BCA ASSESSMENT REPORT

**PROPOSED WAREHOUSE FACILITY
42 Raymond Ave, Matraville**

Revision 2

Date: 10.03.2022

TITLE: SITE ANALYSIS PLAN & SUMMARY

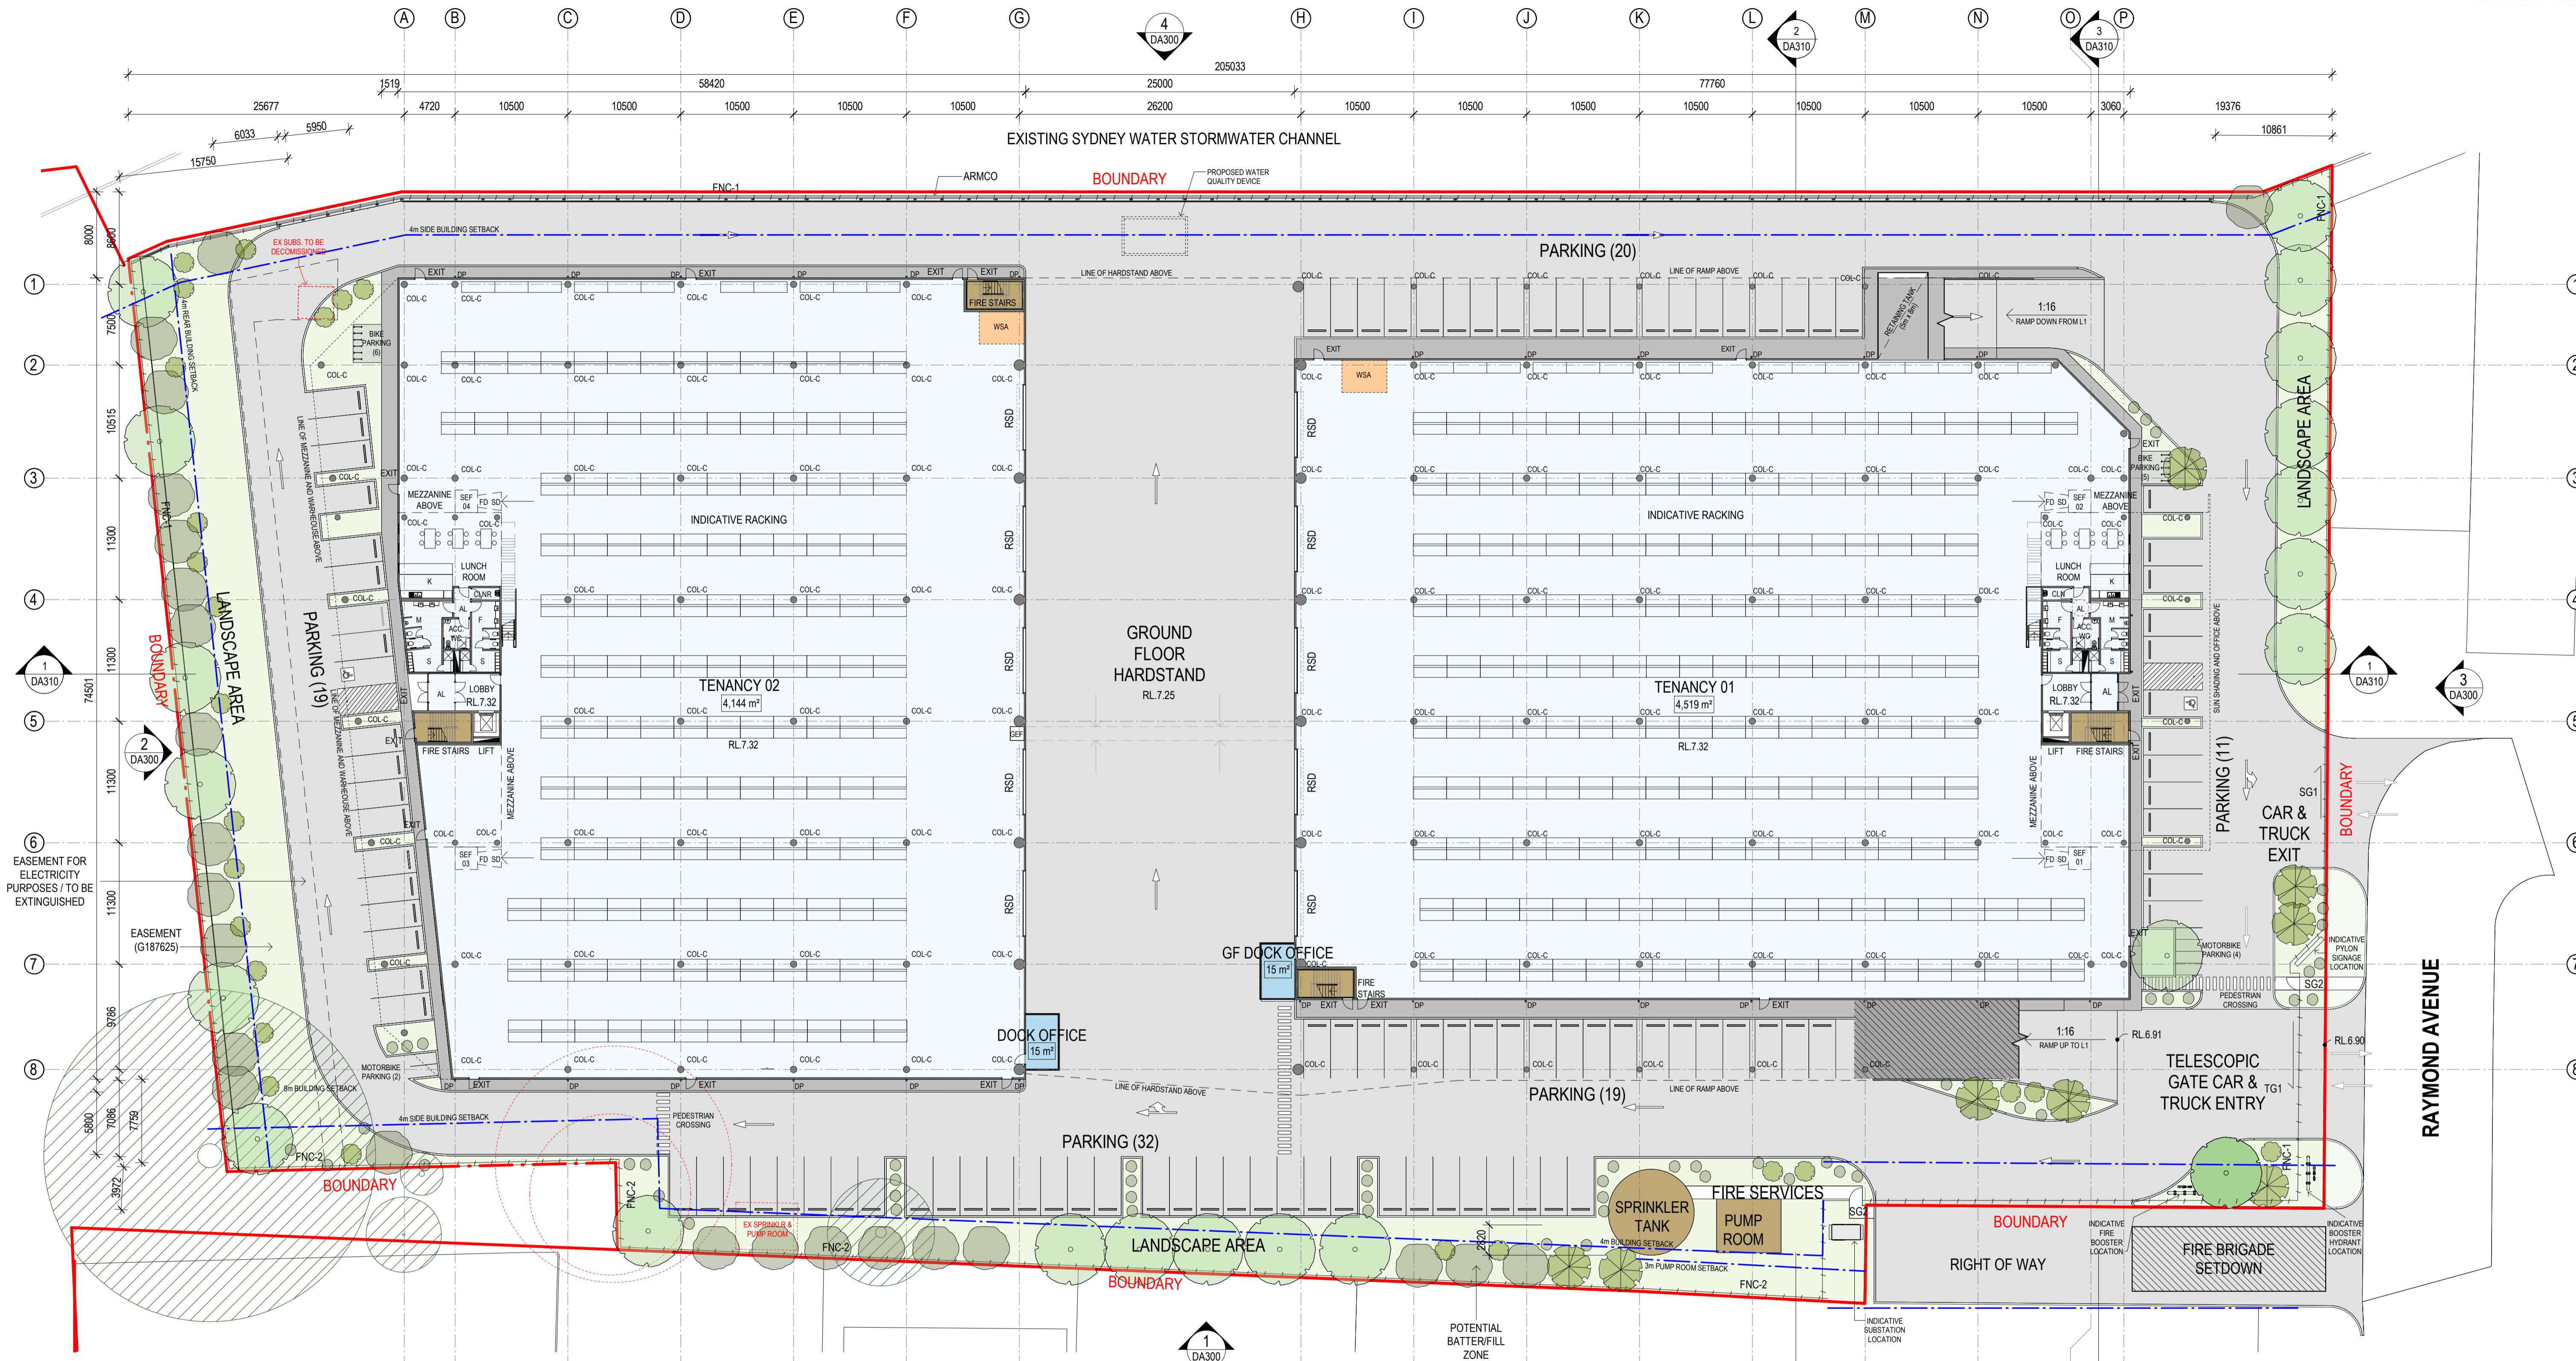
Comments: The perimeter vehicular access is non-compliant with the provisions of this clause in the following areas which are required to be addressed as a Performance Solution by the Fire Safety Engineer (see Appendix 2):

- + Vehicular Access is reduced to less than 6m in width along the western and south-eastern sides (approx. 5.8 clear width measured from kerb to kerb) of Warehouse Tenancy 2- see mark-up below where non-compliances are identified in red.

Note 2: All gates are required to achieve no less than 6m unobstructed width or the reduced width will need to be included in the above Performance Solution.
